MY GARAGE @ NORTHCREST

SITE DEVELOPMENT PLAN
EL PASO COUNTY, COLORADO.

Northcrest Personal Storage PPR
2510 Canada Drive
Colorado Springs, Colorado 80915

PCD FILE NUMBER: PPR-24-012

DRAWING NO.
COVER
SITE DEVELOPMENT PLAN

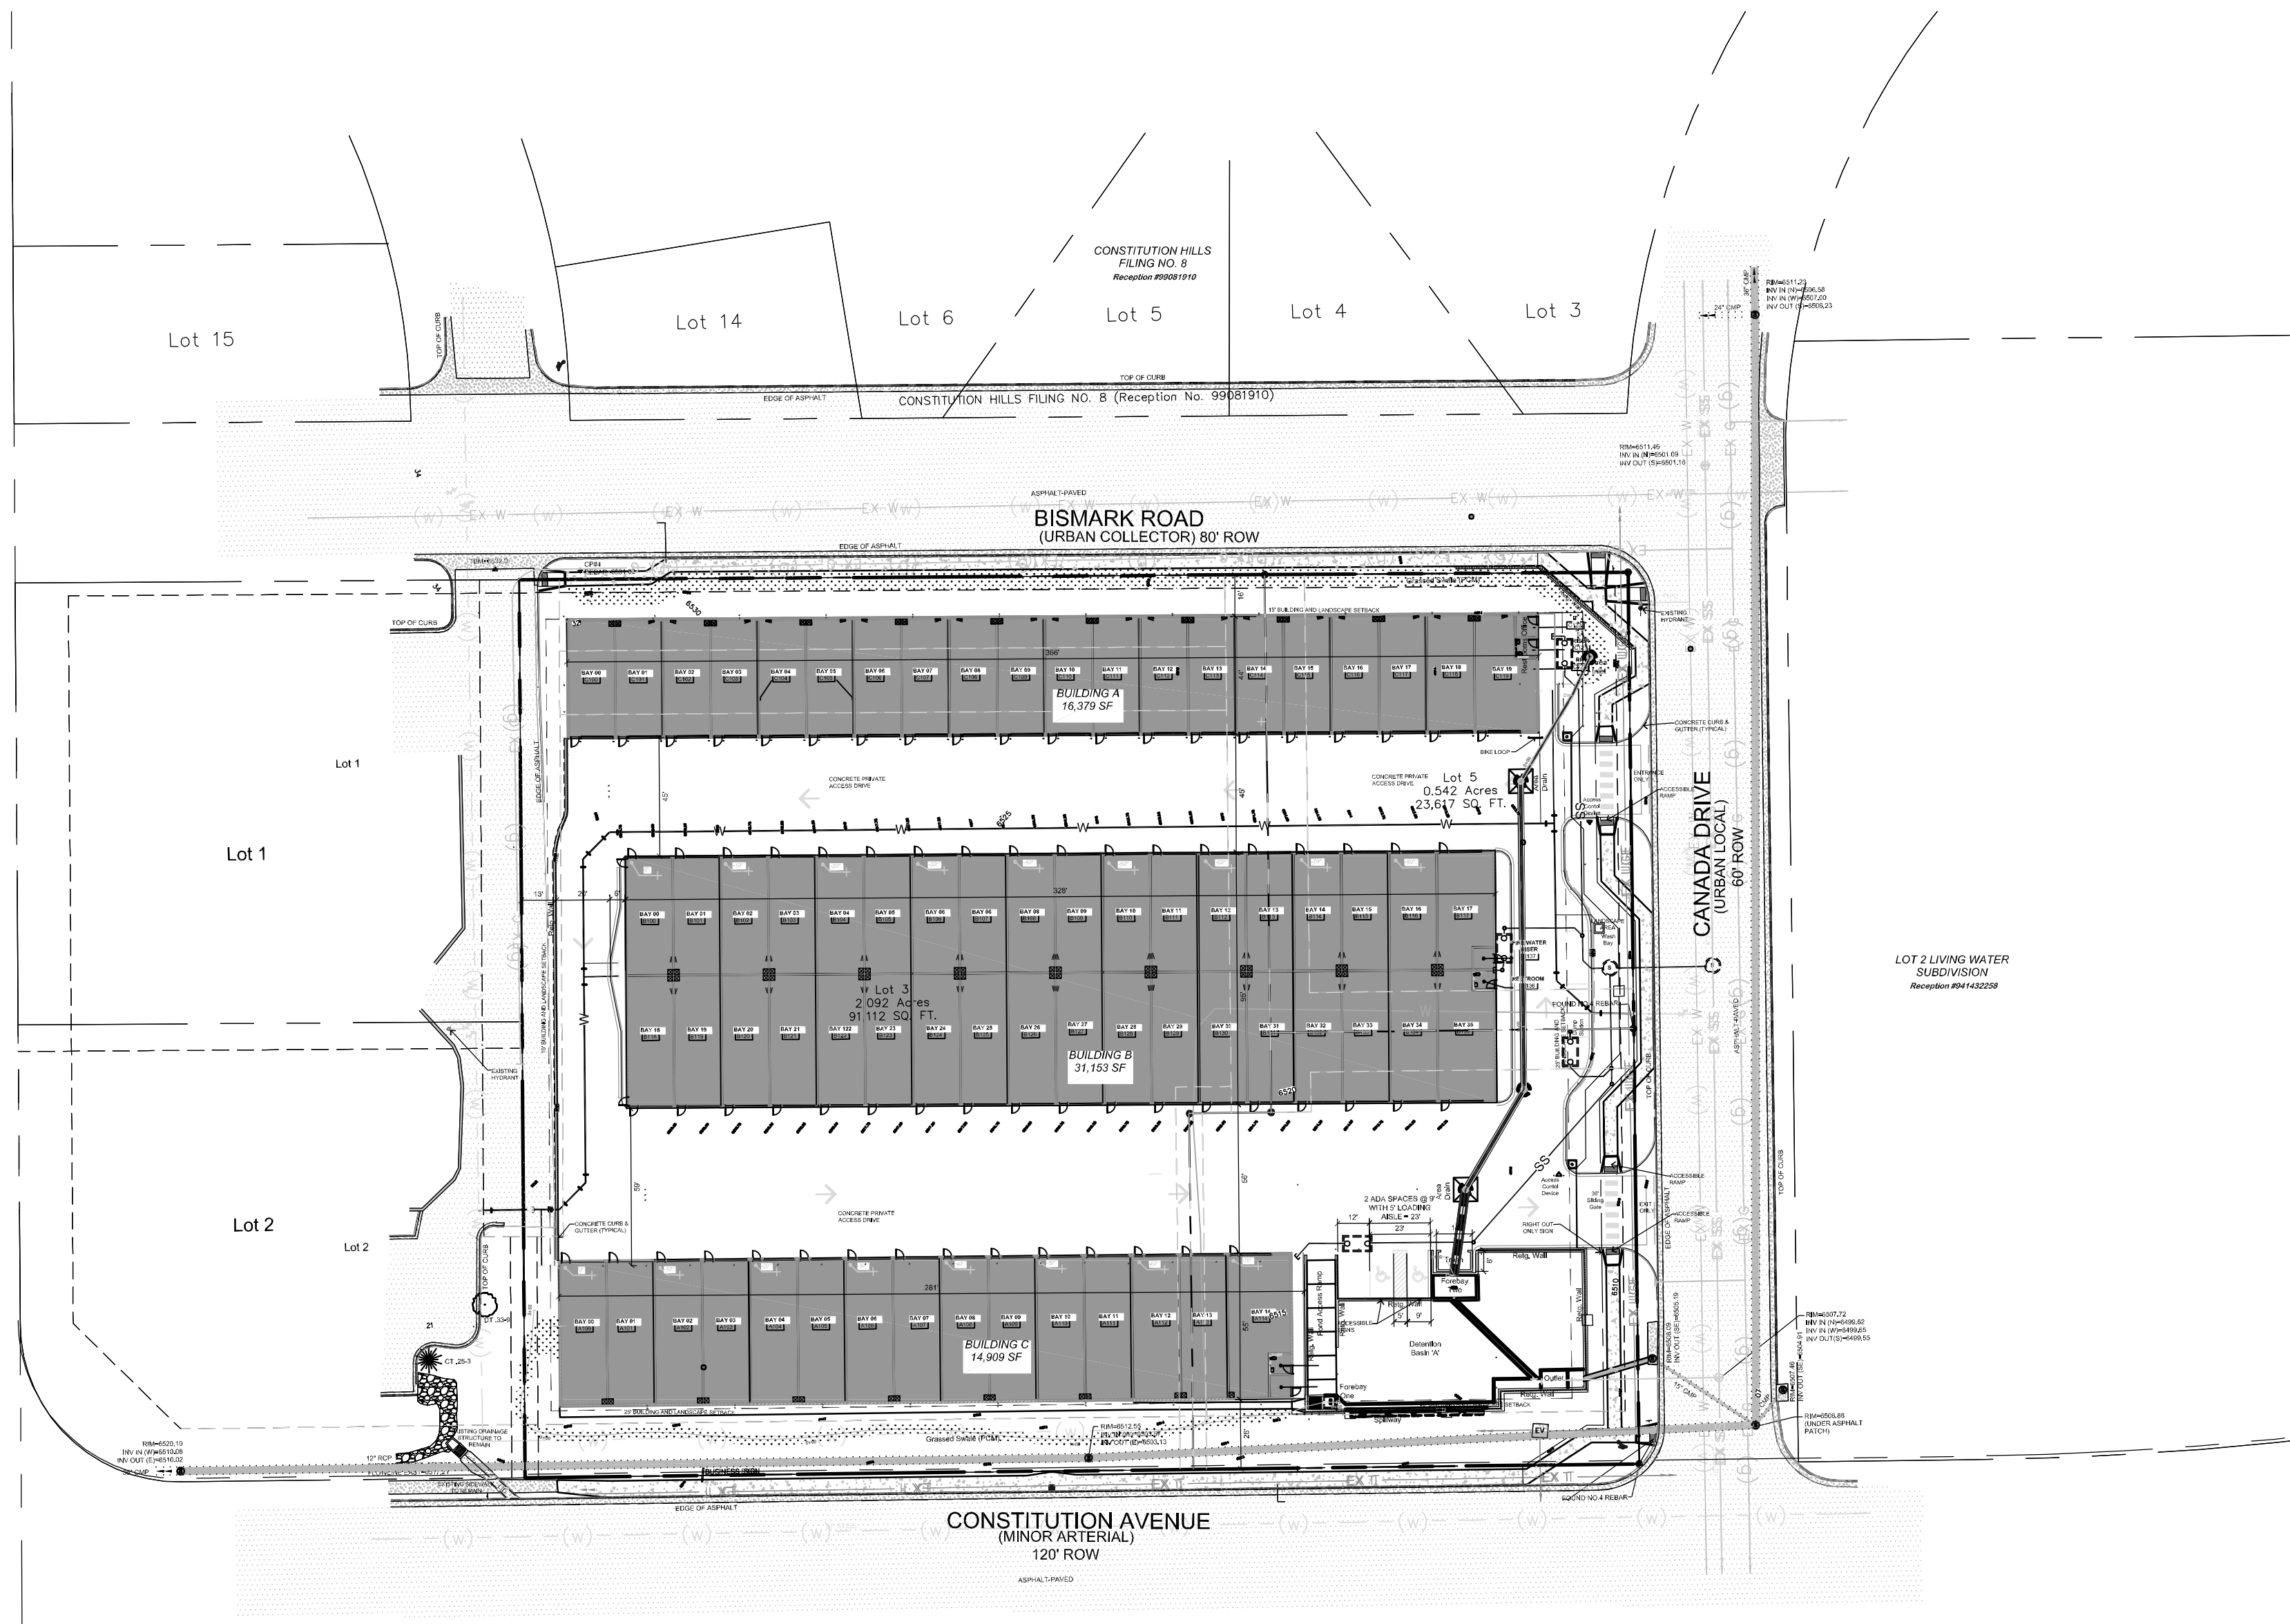
Outstanding comment from V1.
Maximum height in the CC zoning district is 40 Feet.

Outstanding comment from V1.

Outstanding comment from V1.
PCD File Number: PPR2412

DRAWING NO. 1
SITE DEVELOPMENT PLAN

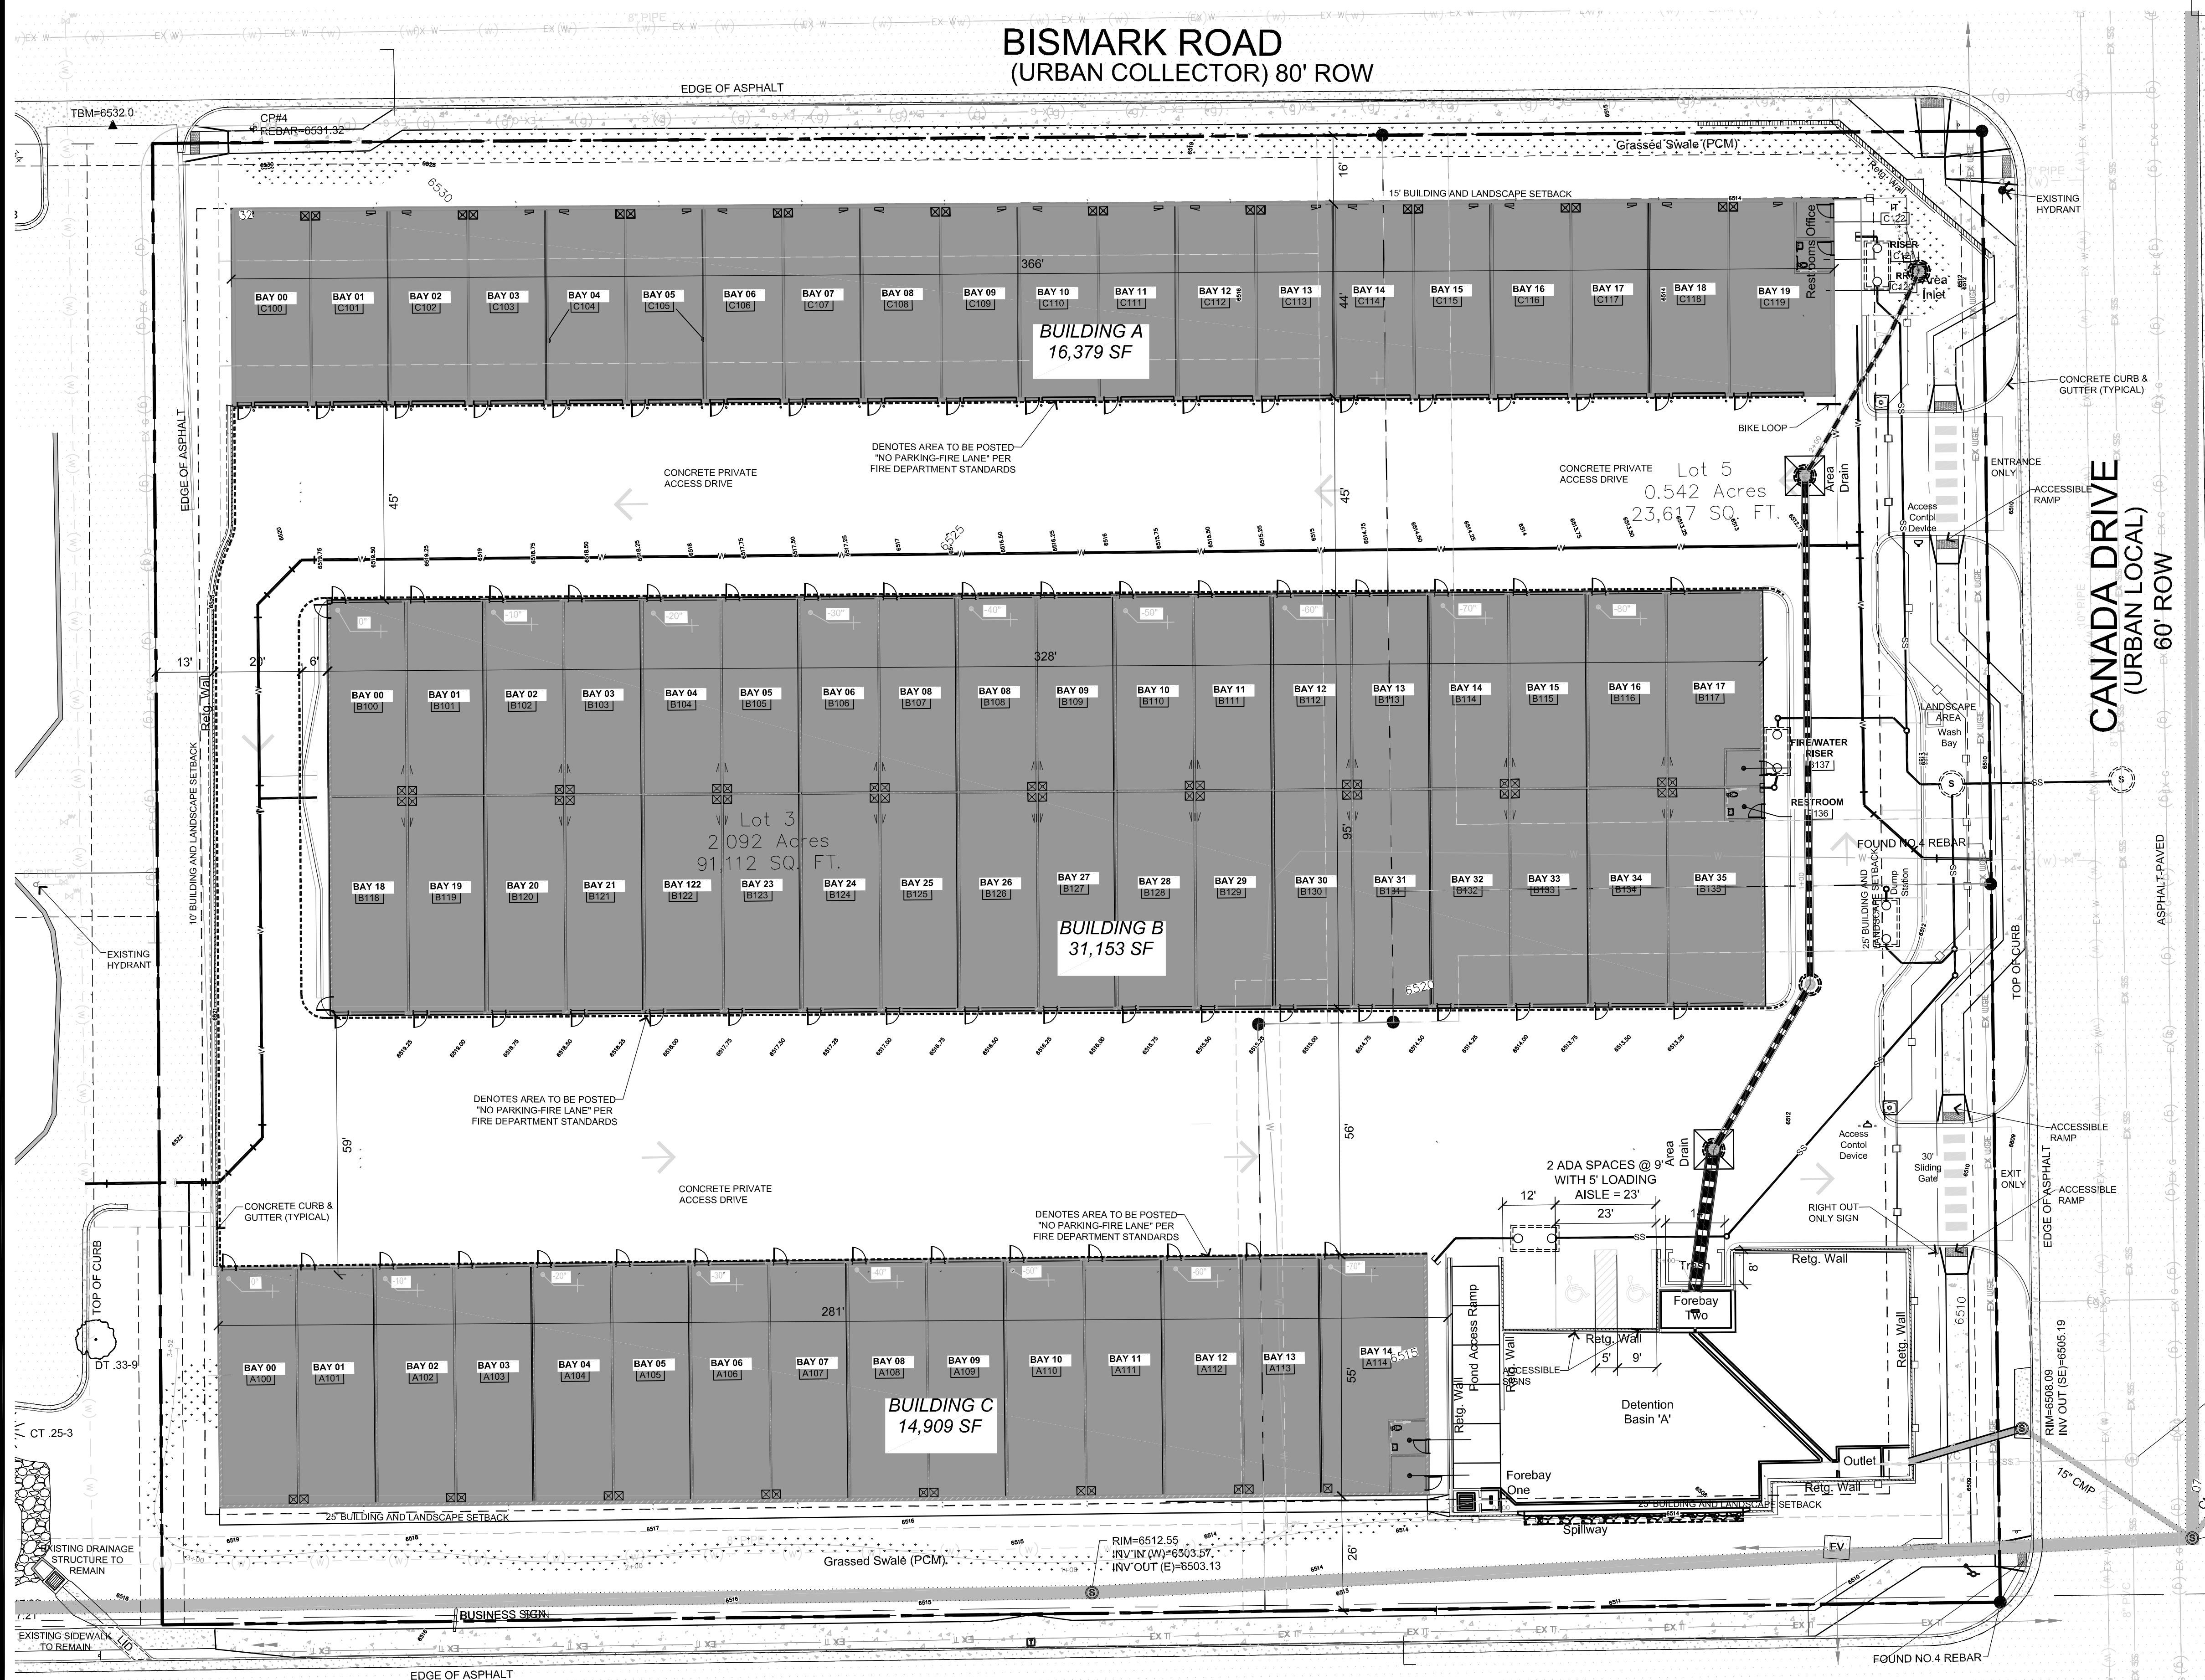
Add note

call out railing for pond perimeter

label any new hydrants FAE lists one.

label as existing hydrant

Outstanding comment from V1.
Maximum height in the CC zoning district is 40 Feet.
